## Consultation Response: Kirklees Council Conservation & Design (Trees)

<b>Date</b>	<i>05 January 2018</i>
<b>Officer responding</b>	<i>Nick Goddard</i>
<b>Application number</b>	<i>2017/94129</i>
<b>Purpose</b>	<i>Initial consultation response</i>
<b>Location</b>	<i>Oakroyd Hall, WYFR headquarters</i>

PLOT 17.

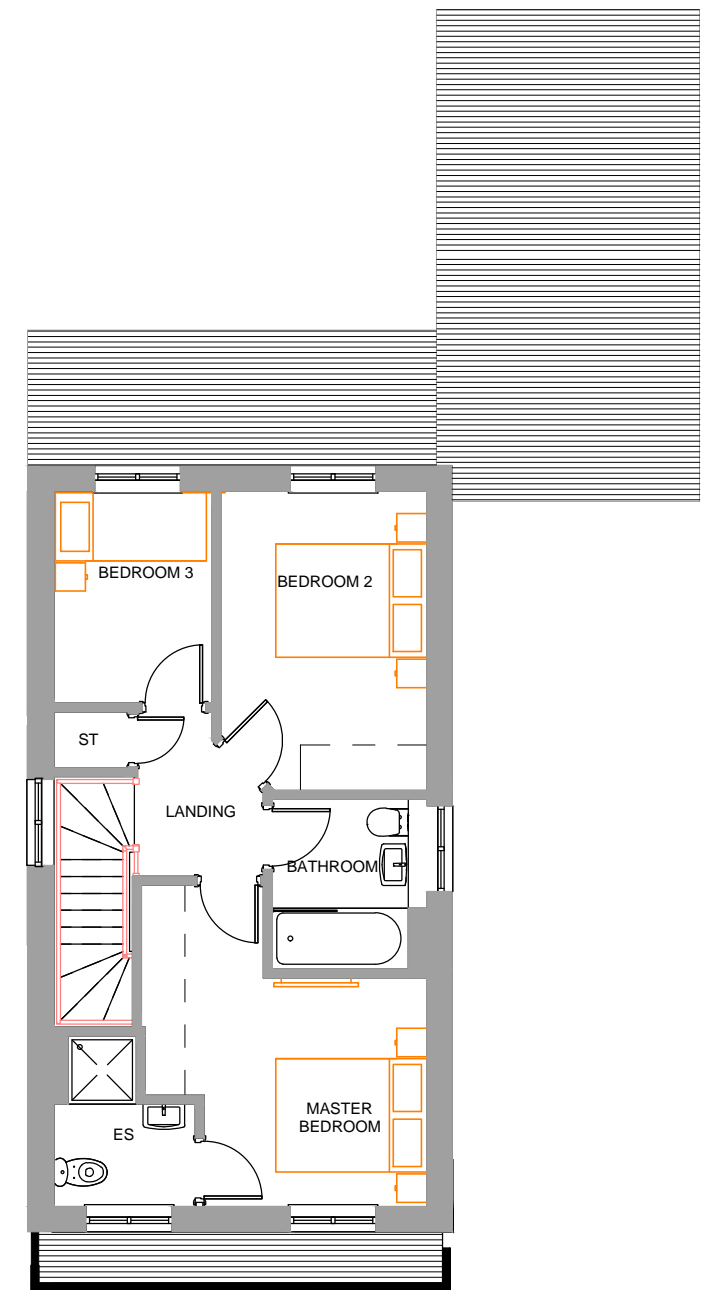
Plot 17 is set back close to the large trees on the site's western boundary. Similarly plot 27 on the northern boundary appears to have little useable outdoor space. Both of these points highlight the need for an accurate tree survey to be undertaken as the crowns on site are larger, in some cases considerably, than those shown or recorded in the 2015 survey. The offsite trees not shown adjacent to Plot 27 are a particular concern again highlighting the need for an up to date survey.

I would require an up to date and accurate tree survey of the site in accordance with BS5837:2012. Using this updated survey an Arboricultural Method Statement and Tree

Protection Plan should be provided to show how the proposals could be constructed whilst successfully retaining the trees as shown on the submitted layout.

Plot 01, 26 & 27.

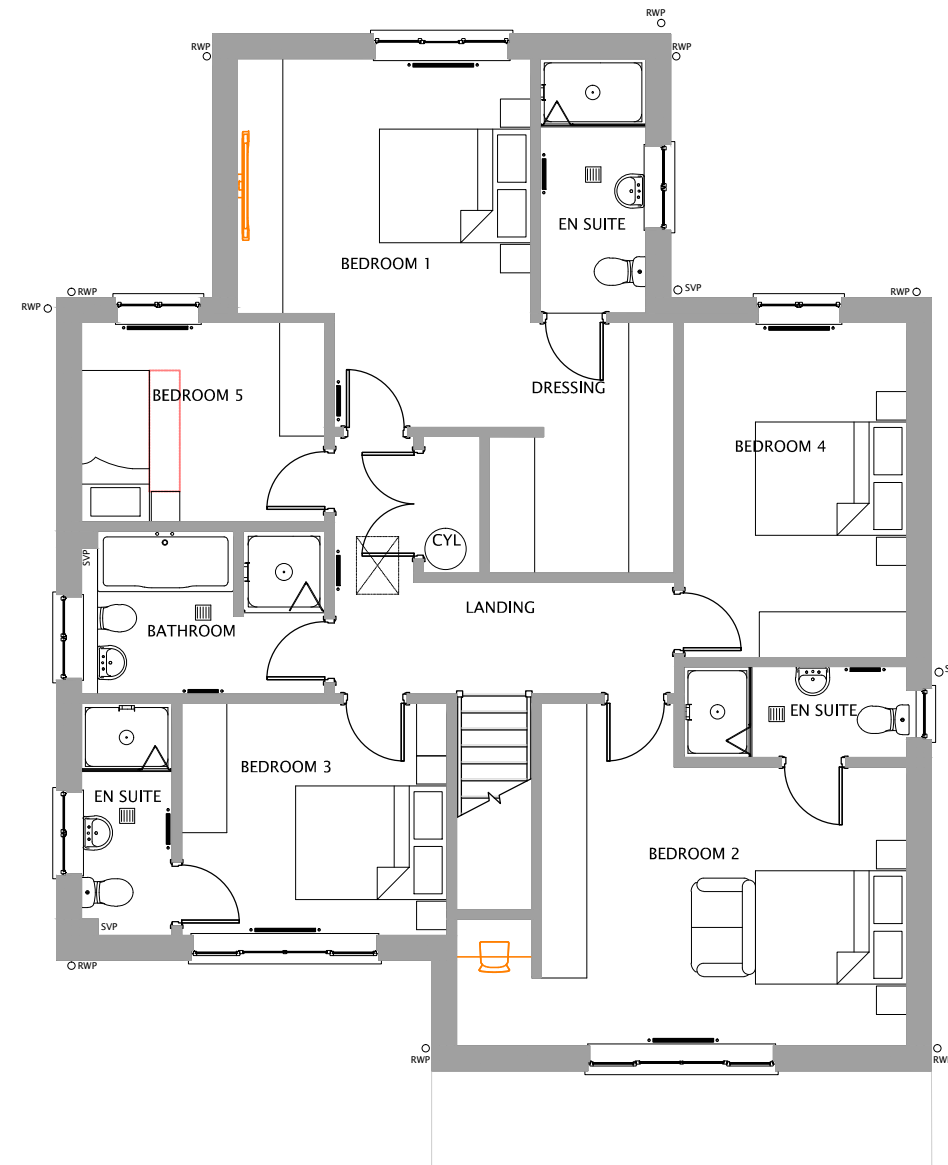
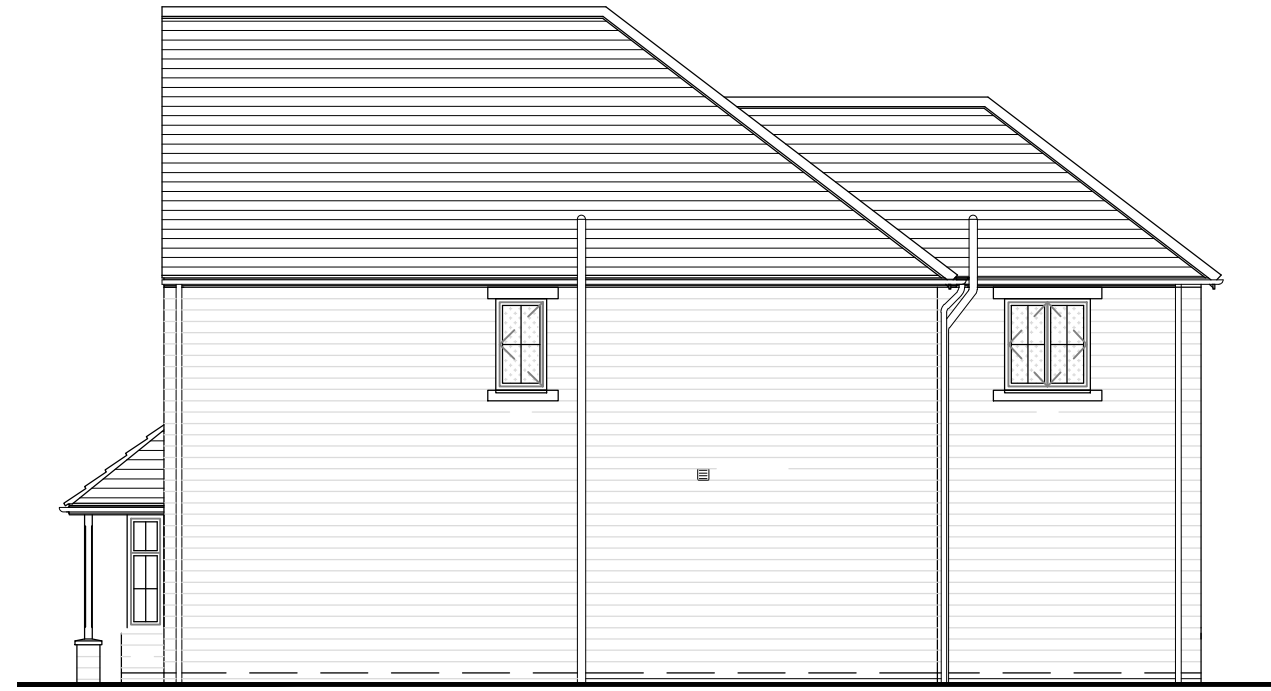
In addition I have concerns regarding the size and position of Plot 1. As shown it is too close to trees on the road frontage, indeed it is within the RPA of a protected mature beech tree. This would appear to be caused by the scale and positioning of the plot, something which is at odd with the approved outline layout.
